Appeal Decision

Appeal Ref: APP/R5510/D/15/3028095

15 Ross Close, Hayes UB3 1TS

1. The appeal is allowed and planning permission is granted for the part conversion of an existing single storey outbuilding to habitable use for use as a granny annex involving alterations to the front elevation, at 15 Ross Close, Hayes UB3 1TS in accordance with the terms of the application Ref 10285/APP/2015/12, subject to the following conditions:
 - 1) The development hereby permitted shall begin before the expiration of three years from the date of this decision.
 - 2) The development hereby permitted shall be carried out in accordance with the following approved plans: AUG/14/11 Rev DEC/14.
 - 3) The building hereby permitted to be used as a granny annex shall not be occupied at any time other than for purposes ancillary to the residential use of the dwelling at 15 Ross Close.

DWG NO:- AUG/14/11.

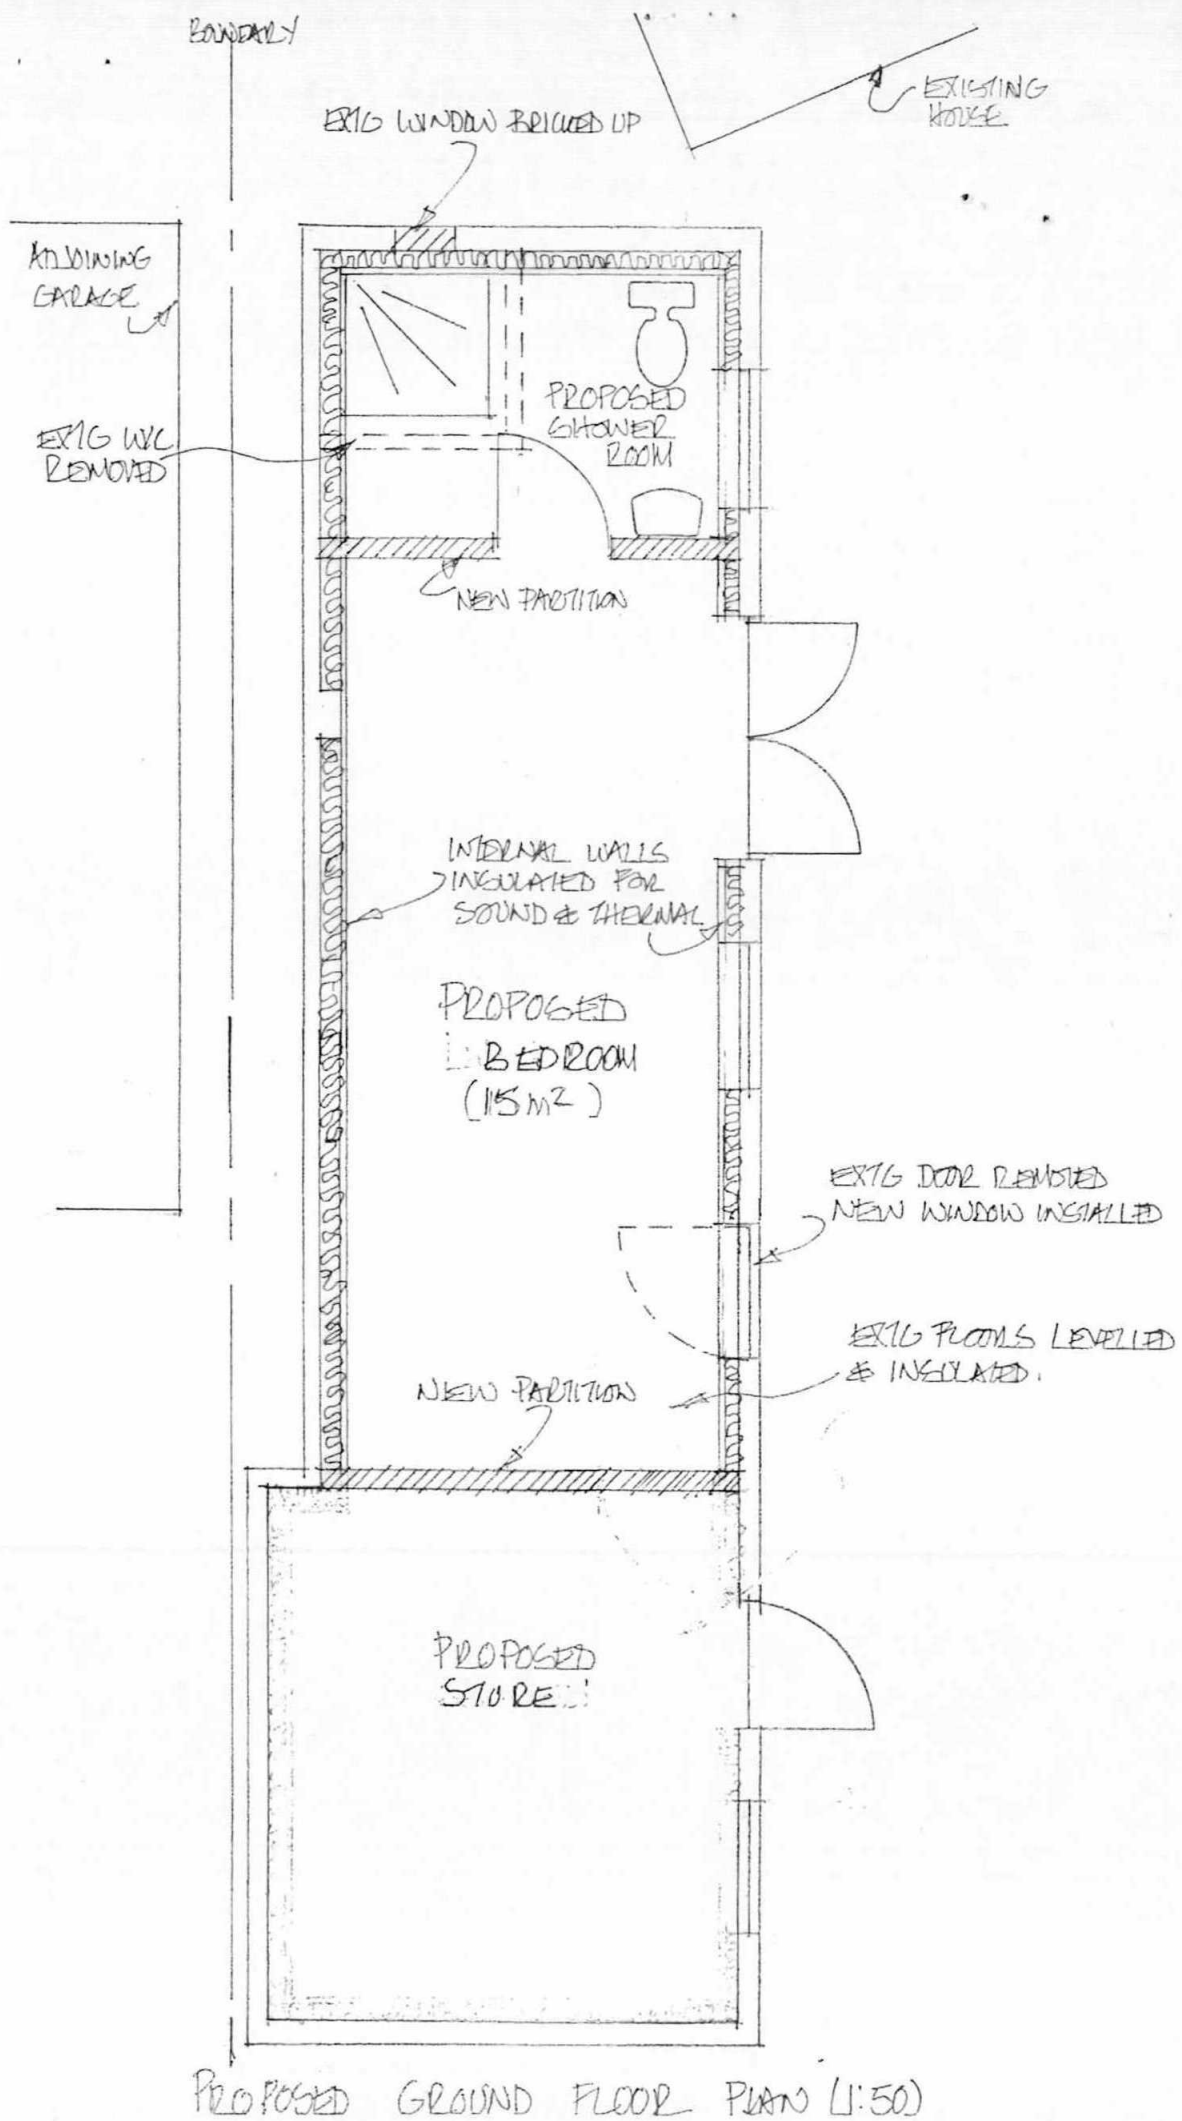
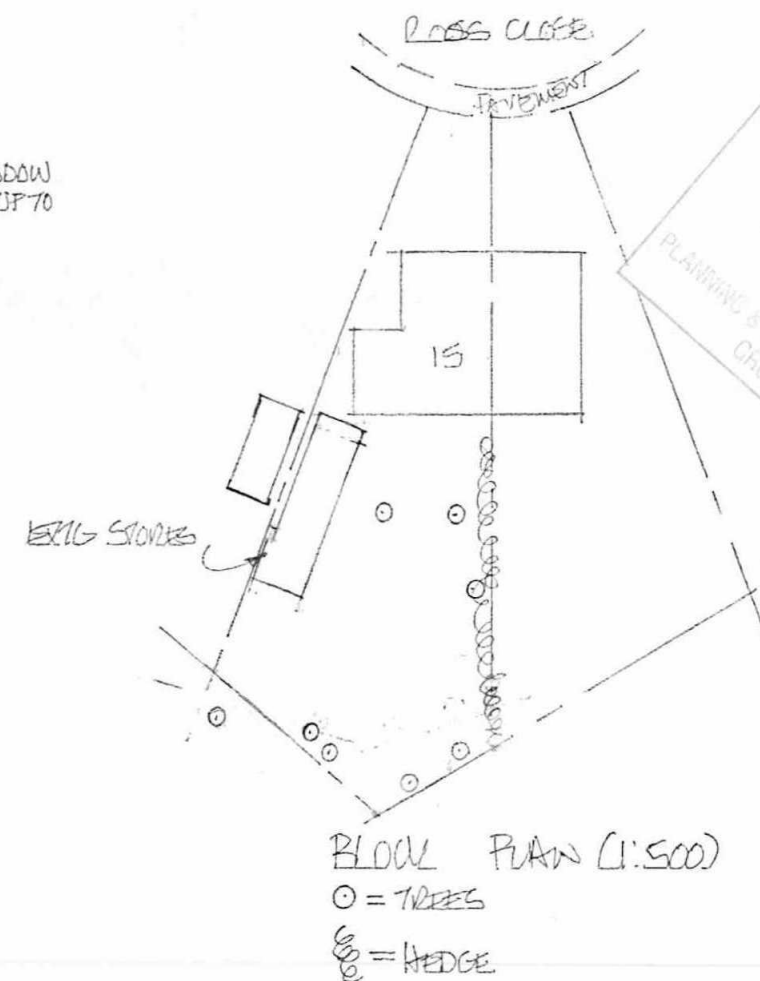
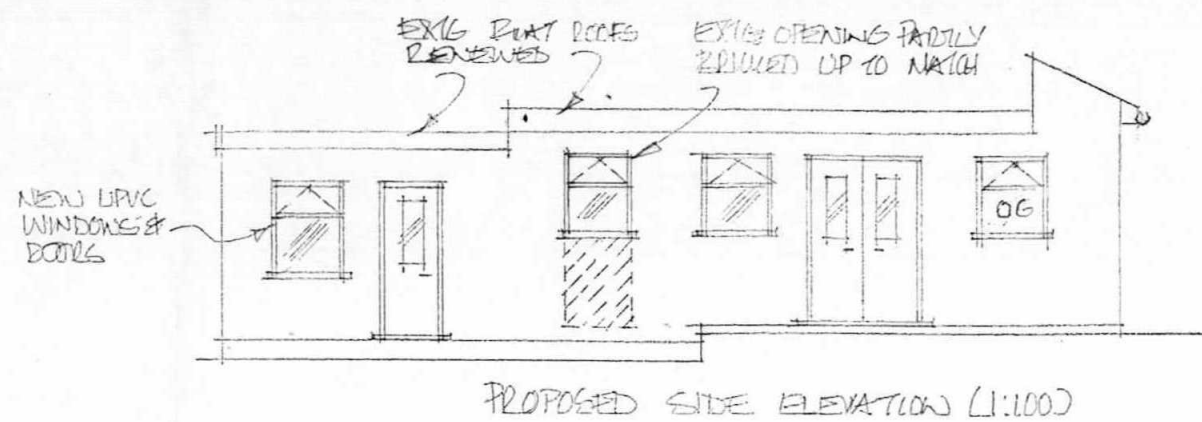
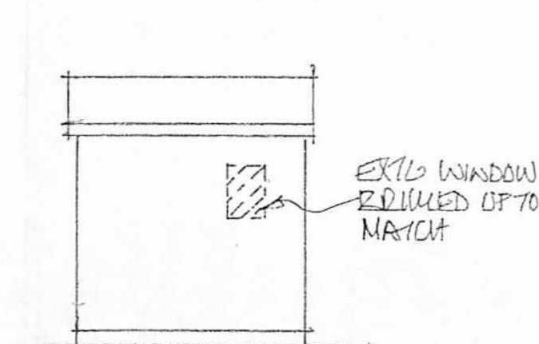
6. However, this calculation appears to include the store, which would not form part of the annex. The submitted drawing shows that the bedroom would only have an area of about 15 sq m, with the only other space comprising a relatively small shower room/WC. The accommodation would therefore be fairly modest in extent and significantly smaller than the Council suggests.

7. A side gate into the rear garden would enable the entrance to the annex to be reached from the street without going through the house at 15 Ross Close, contrary to the SPD. However, this would only be possible through a particularly narrow gap between the house and annex. As a result it seems to me that access to the new accommodation may well be fairly dependent on going through the associated dwelling, especially in relation to the movement of bulky items such as furniture. Even more significantly, the converted building would not have a kitchen, so that all the necessary facilities for independent occupation would not be available.
